| Application Ref:            | 2025/0688 |              |     |  <div>Ribble Valley<br/>Borough Council</div> <hr/> <div><a href="http://www.ribblevalley.gov.uk">www.ribblevalley.gov.uk</a></div> |
| DELEGATED ITEM FILE REPORT: |           |              |     | APPROVAL                                                                                                                                                                                                              |

| Development Description: | Proposed reinstatement of previously approved phase 1 entrance, including a timber fence between phase 1 and phases 2/3 |
| Site Address/Location:   | Former Genus Site (Units 1-21 Mitton Road Business Park) Mitton Road Whalley BB7 9JY                                    |

Client A I Land Ltd		
Project Proposed Alterations to Phase I Entrance at Mitton Road Business Park Whalley		
Drawing Title Existing and Proposed Site Plans		
Scale 1:500 @ A2	Date Aug 2025	Drawn LFR
READ DESIGN LTD		
102 - 09 c

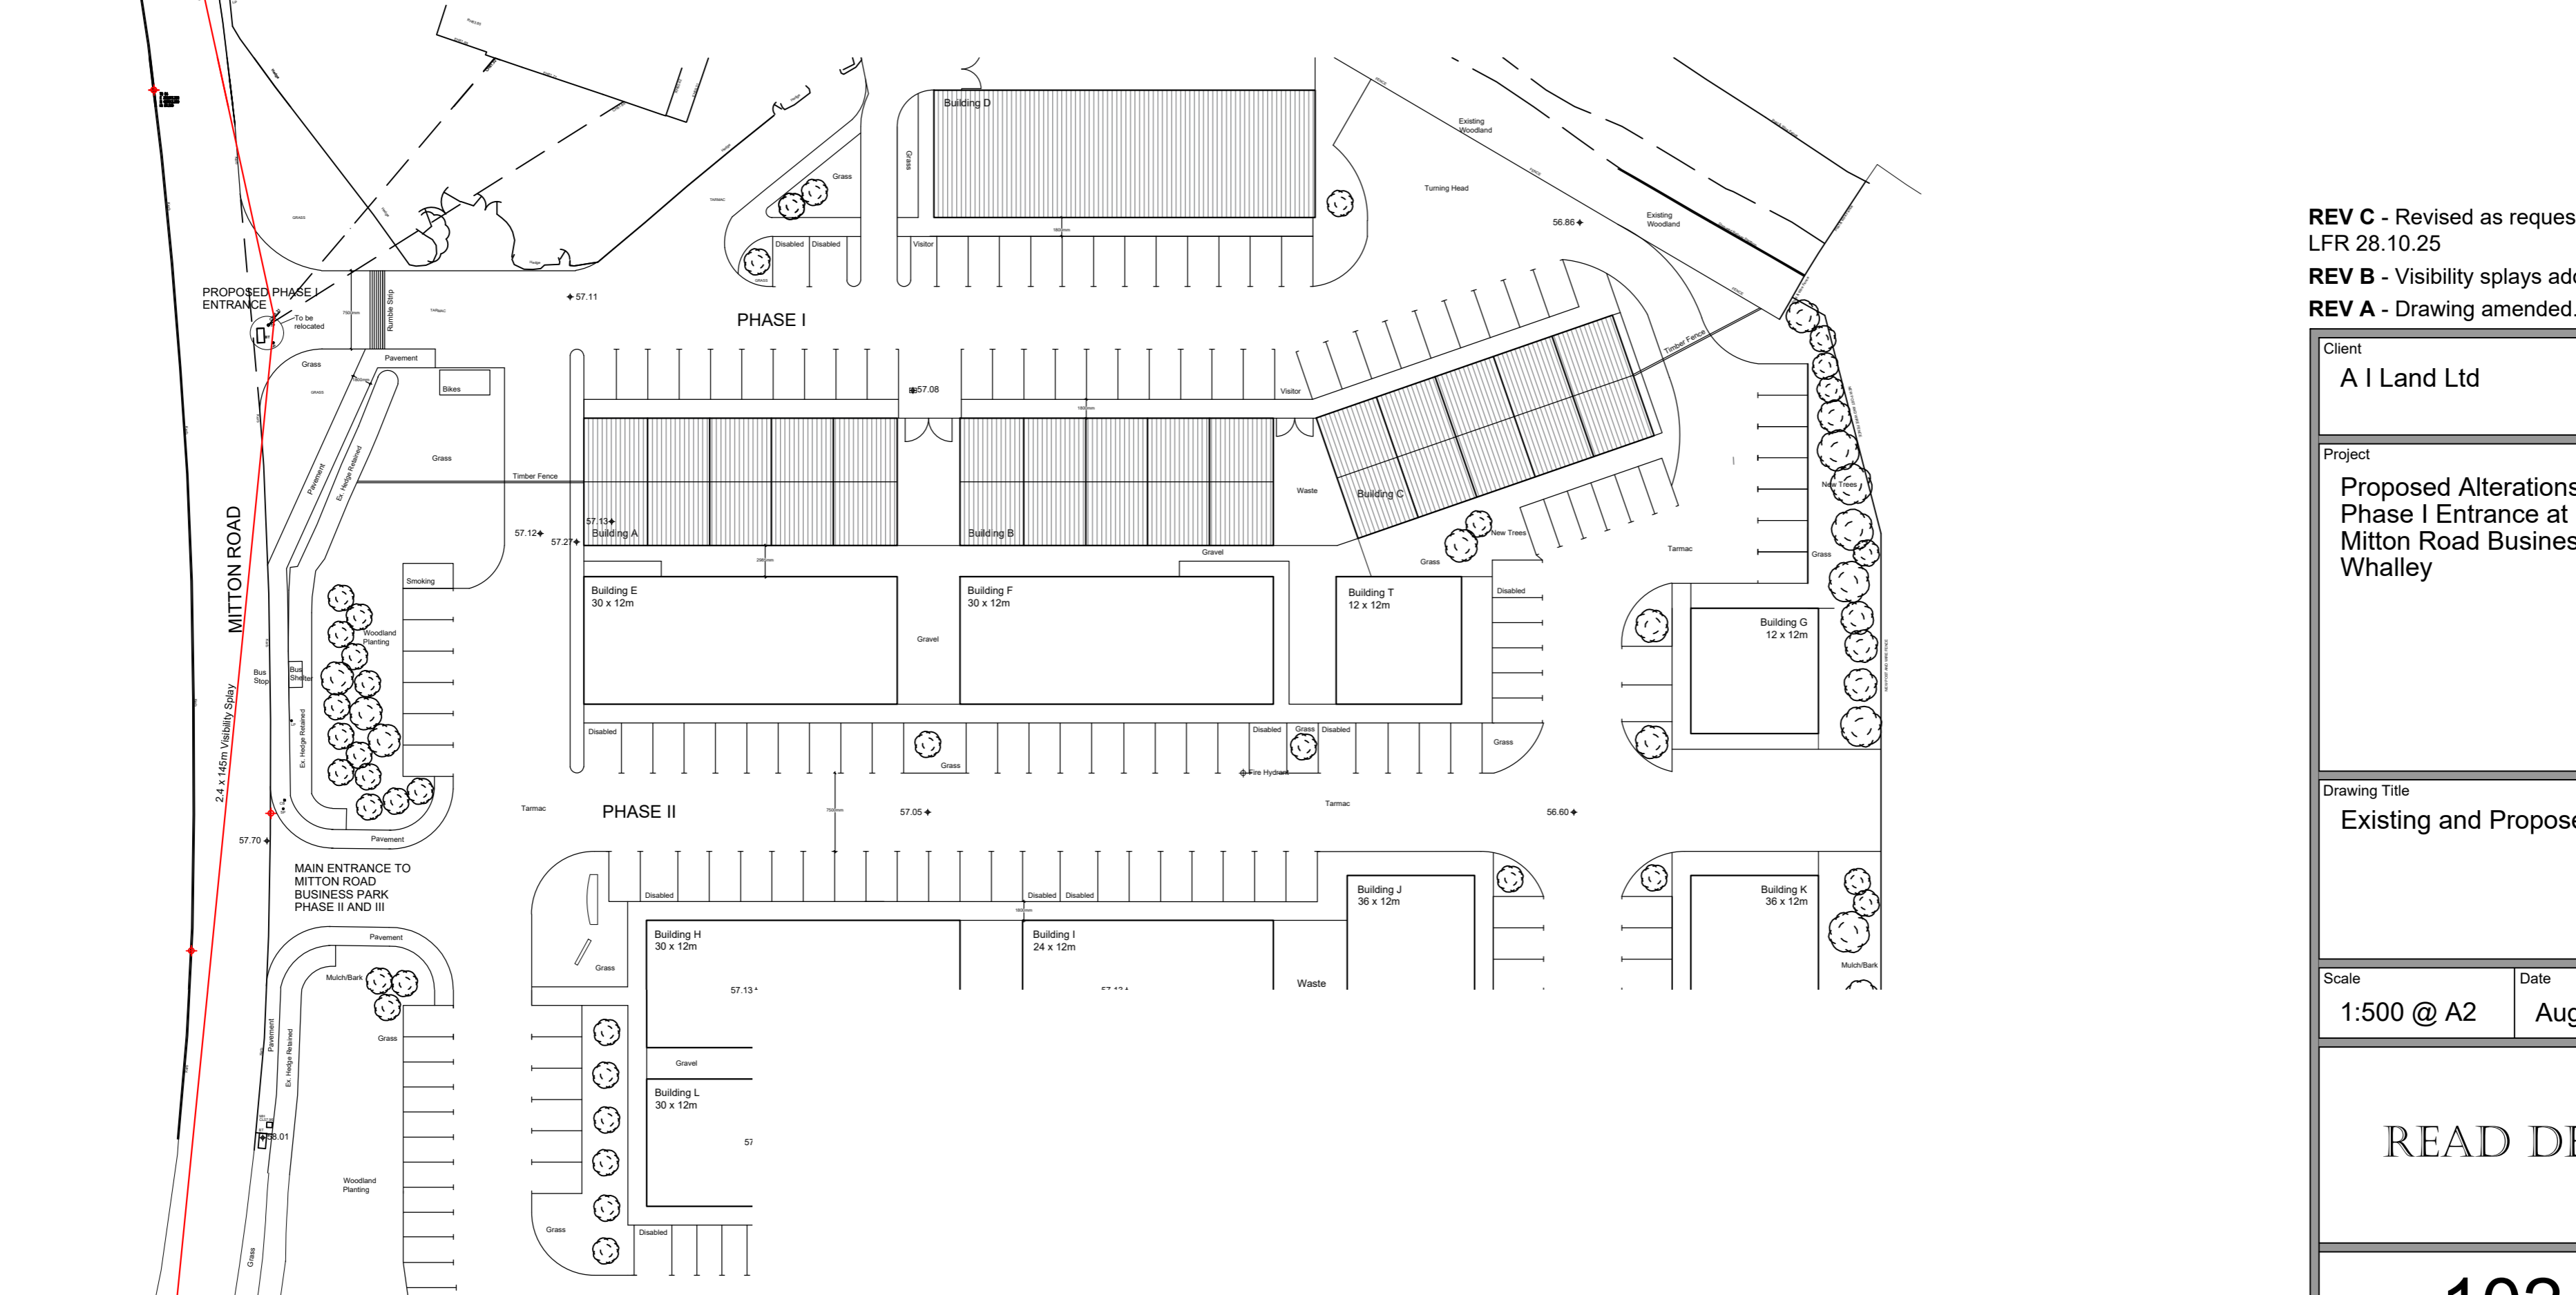
The application seeks to widen an access on Mitton Road which is currently restricted by condition to serve the cottages, pedestrian/cycles and as an emergency access for the commercial units. It is noted that the internal measures to restrict access are not implemented.

The access is proposed to serve Phase 1, 16 commercial units and the cottages. These units are currently served from the new access serving the wider site, phases 1 and 2. Internally a fence will be erected to separate Phases 1 and 2/3 for all vehicles, pedestrian access will be maintained and a new bike store provided.

Mitton Road is subject to a 30mph speed limit, increasing to the national speed limit approximately 150m north of the site access. The visibility at the site access is considered acceptable. Splays of 2.4m by 90m to both sides are required and can be achieved over the highway or applicants land. The access has been increased in width from 5.5m to 7.5m as previously requested. The radius to both sides has been increased from 6m to 12m to accommodate the longest articulated vehicles. The access widening will need to be completed under a S278 agreement with Lancashire County Council.

The proposed internal separation of Phases 1 and 2 will allow pedestrian access to be maintained, although gated, between Phases 1 and 2 for overspill car parking which is considered necessary. The gates should be unlocked or suitably managed to allow pedestrians to move between the two phases.

- The plans submitted do not reflect the current situation on the ground i.e. an extension to Building D is not shown, and a single access road to the side / rear of Building D together with physical barrier at the end next to the residential properties is shown but not in situ. It is important to note that these all relate to land outside of the red edge that does not directly impact on the proposal. It is also important to note that in assessing the scheme regard has been had to both the plans and the situation on site, assuming this will remain. In respect of the single access road shown to the side / rear of Building D with physical barrier next to the neighbouring properties, neither of which are in situ, it is acknowledged this was included on the approved layout plan for phase 2/3 however it was not shown or relied on for the approved Phase 1 layout. The access arrangement as proposed would mimic the approved Phase 1 layout and is deemed acceptable regardless of whether this access road detail (and in turn barrier) is installed. In respect of the single storey rear extension to the rear of Building D which is not shown on the plans, this appears on Google imagery dating back to 2018 as such would be exempt from any enforcement action, and its existence has no bearing on the assessment of the application.
